EMAIL FROM DP&E

Subject: Boral - Peppertree Quarry MOD4 - Comments on Background Scoping Document

I refer to your email of 11 August 2015, advising of the application for a modification to the current Project Approval (PA 06_0074). Good to talk with you on Friday and discuss some of the points below.

FIGURE 2  
Local context  
BACKGROUND SCOPING DOCUMENT  
PEPPERTREE QUARRY MODIFICATION 4

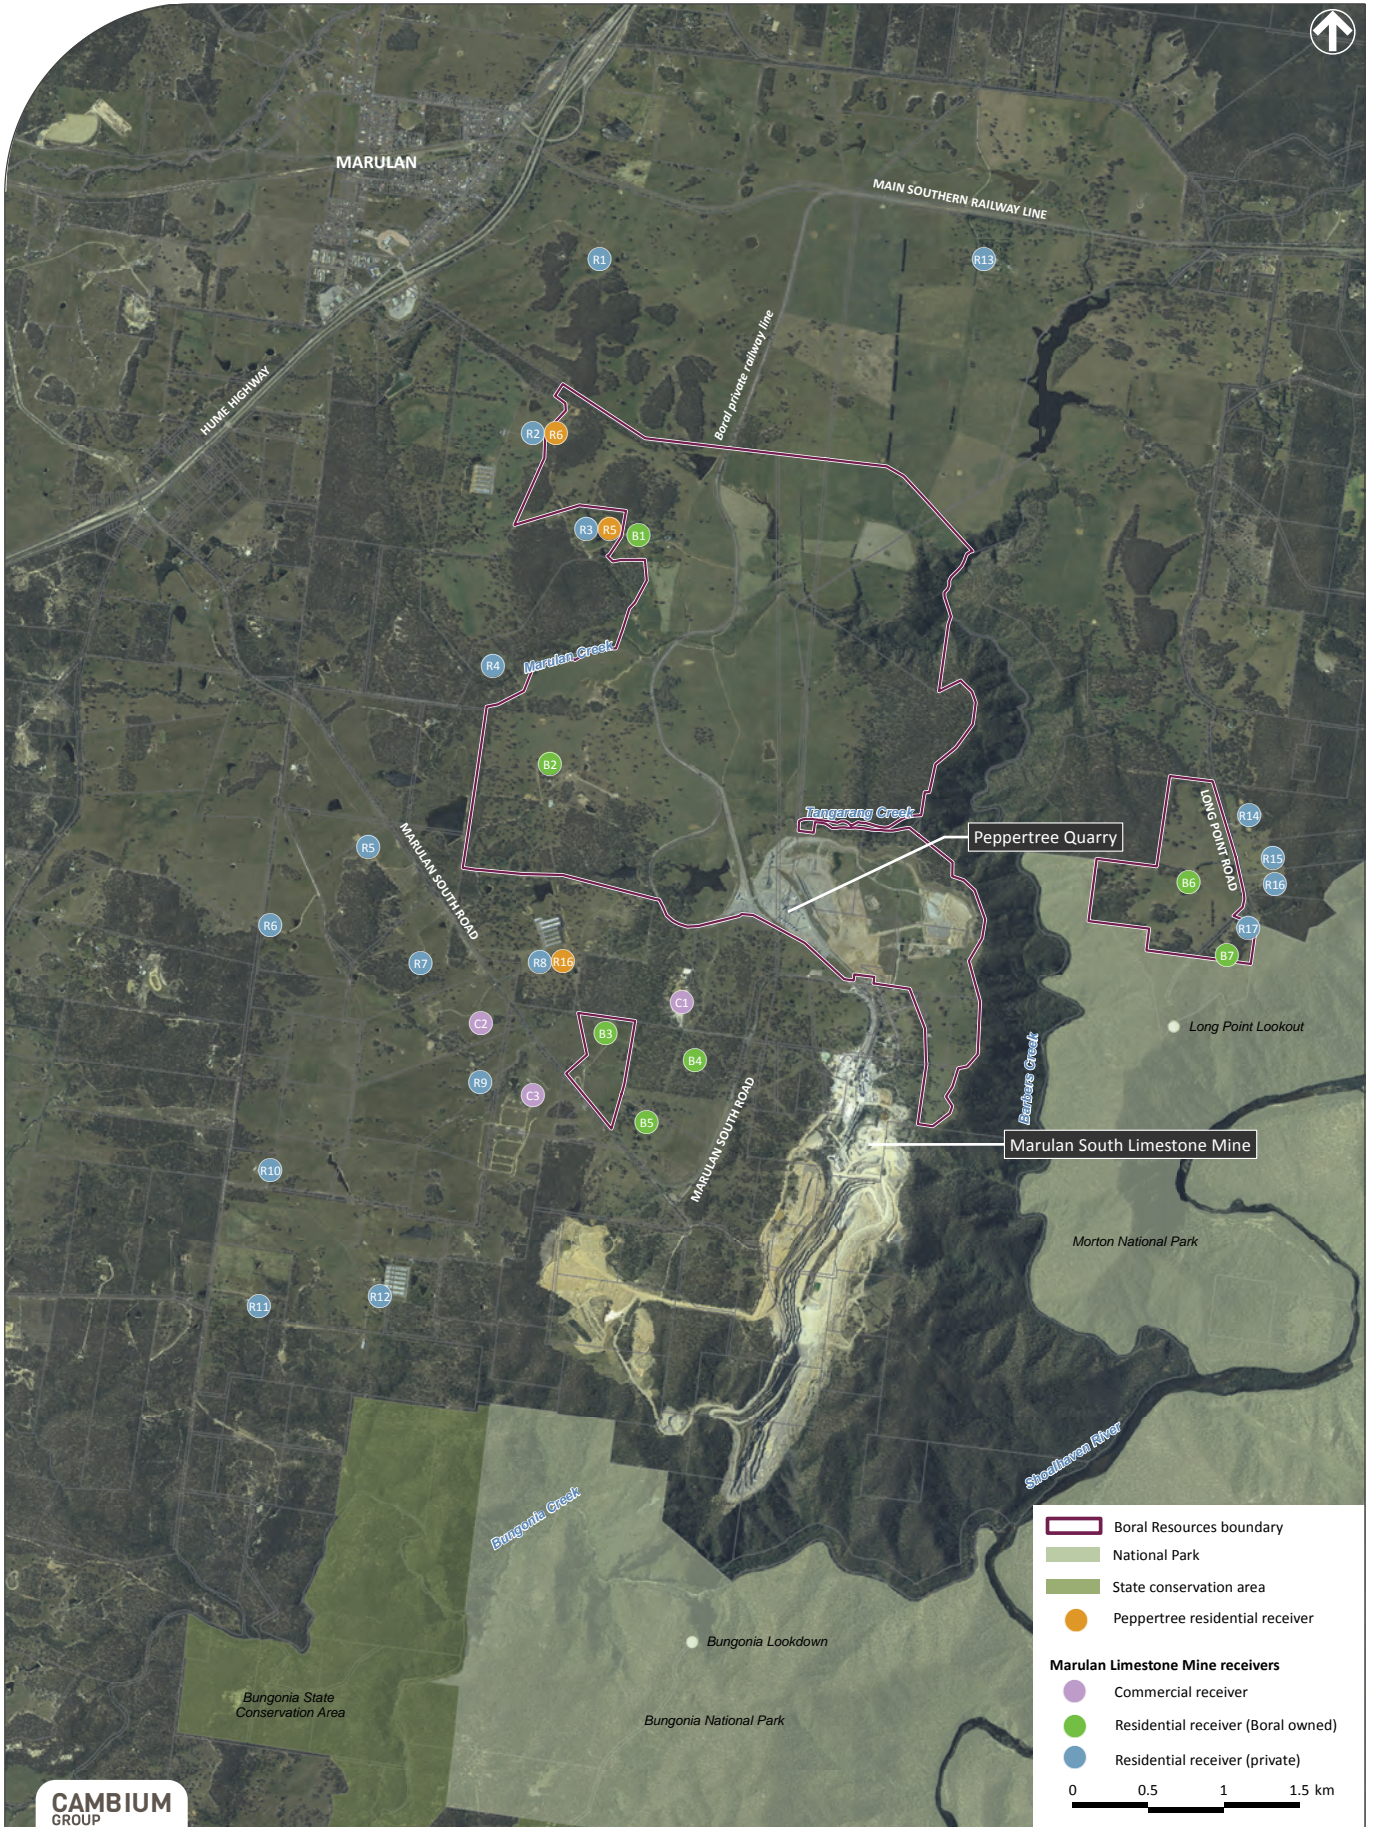
- describe in detail the in-pit processing activities in the EA, considering that impacts from the proposed changes to the operating hours for the in-pit activities are being assessed;
- describe and show the location of existing and proposed haul/access roads in a figure in the scoping document;
- show potential sensitive receptors with respect to existing and proposed haul roads (Figure 2) and/or note the need to identify them in the EA;

Stakeholder	Environmental Requirement	Response/BSD Section Reference
	<p>impacts from the proposed changes to the operating hours for the in-pit activities are being assessed;</p> <ul style="list-style-type: none"> show potential sensitive receptors with respect to existing and proposed haul roads (Figure 2) and/or note the need to identify them in the EA; 	<ul style="list-style-type: none"> Noted. Will be explained in the EA. All receptors are identified in Figure 2. As outlined above, existing haul/access roads are evident on the aerial photography. I have focused on the proposed haul route for the MOD4 proposed new southern overburden emplacement. Described in Section 3.1.2 and drawn and labelled on revised Figure 7.
	<p>Environmental Management and Monitoring</p> <ul style="list-style-type: none"> note that a summary of the environmental performance of the operation to date will be included in the EA; 	<ul style="list-style-type: none"> Noted. Will be included in the EA.

FIGURE 7  
The Project  
BACKGROUND SCOPING DOCUMENT  
PEPPERTREE QUARRY MODIFICATION 4

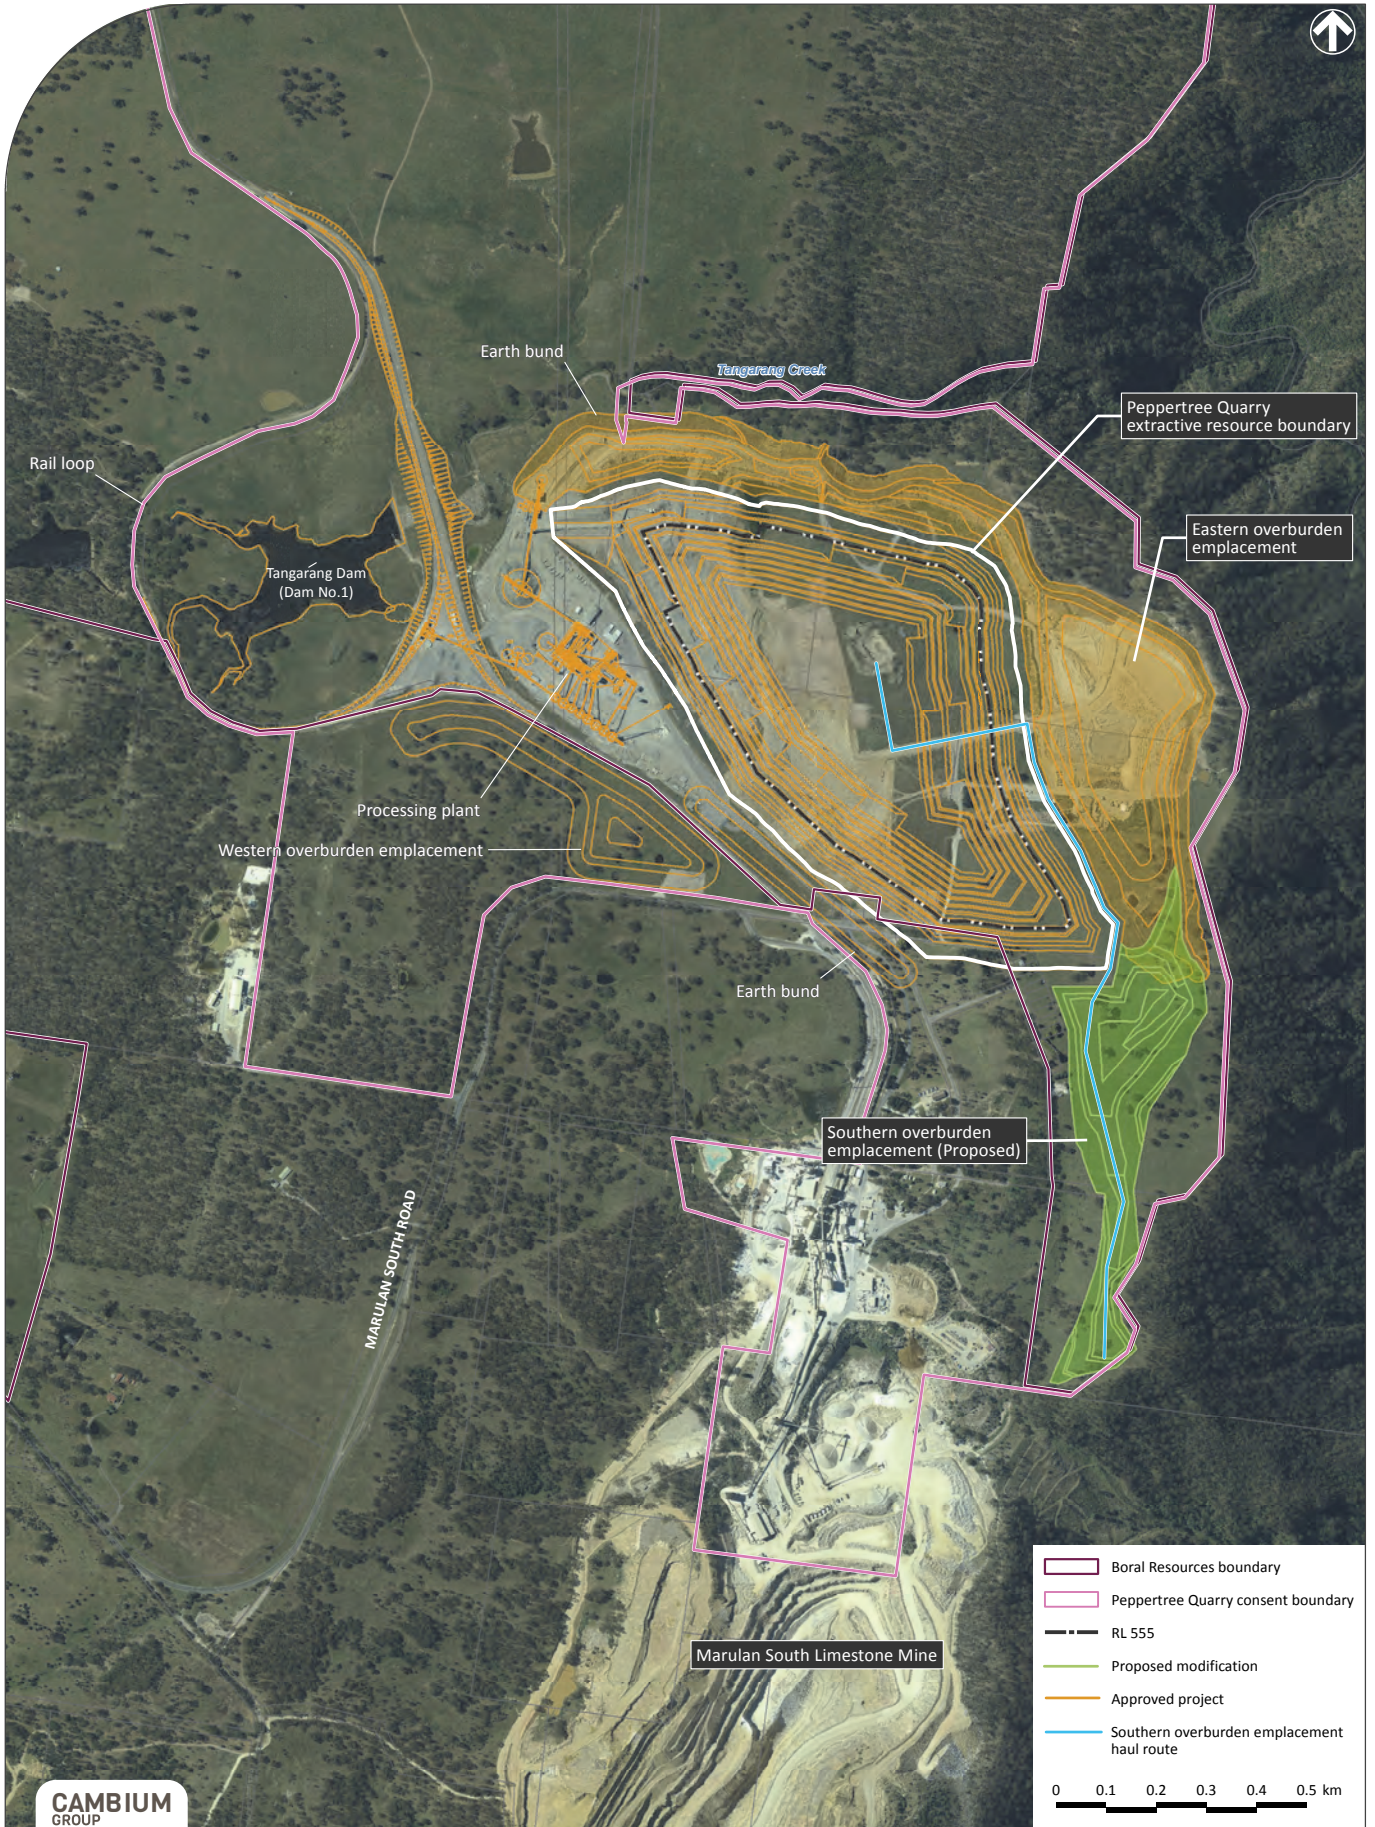
- estimate the volume of material proposed for overburden emplacement and the time period over which emplacement would occur and include in the scoping document;

- note in the scoping document the extent to which the location of the proposed emplacement area may impact on access to the quarry resource and/or cause any sterilisation of the resource;
- describe in more detail in the EA the current and proposed use of the western emplacement area and its relationship to activities under the proposed modification;

Stakeholder	Environmental Requirement	Response/BSD Section Reference
Department of Planning and Environment (DP&E)	To Be Addressed in the Background Scoping Document:	
	<p>The Applicant</p> <ul style="list-style-type: none"> include details about land ownership in the scoping document, noting that Boral is the owner of the land and that landowner consent is not required (as noted in the application); 	Addressed in Section 1.3.
	<p>Planning Approval History</p> <ul style="list-style-type: none"> substitute in Appendix A in the scoping document, the latest consolidated project approval which includes MOD 3 in 2012; 	Substituted.
	<p>Quarry Activities and Infrastructure</p> <ul style="list-style-type: none"> describe and show the location of existing and proposed haul/access roads in a figure in the scoping document; 	Existing haul/access roads are evident on the aerial photography. I have focused on the proposed haul route for the MOD4 proposed new southern overburden emplacement. Described in Section 3.1.2 and drawn and labelled on Figure 7.
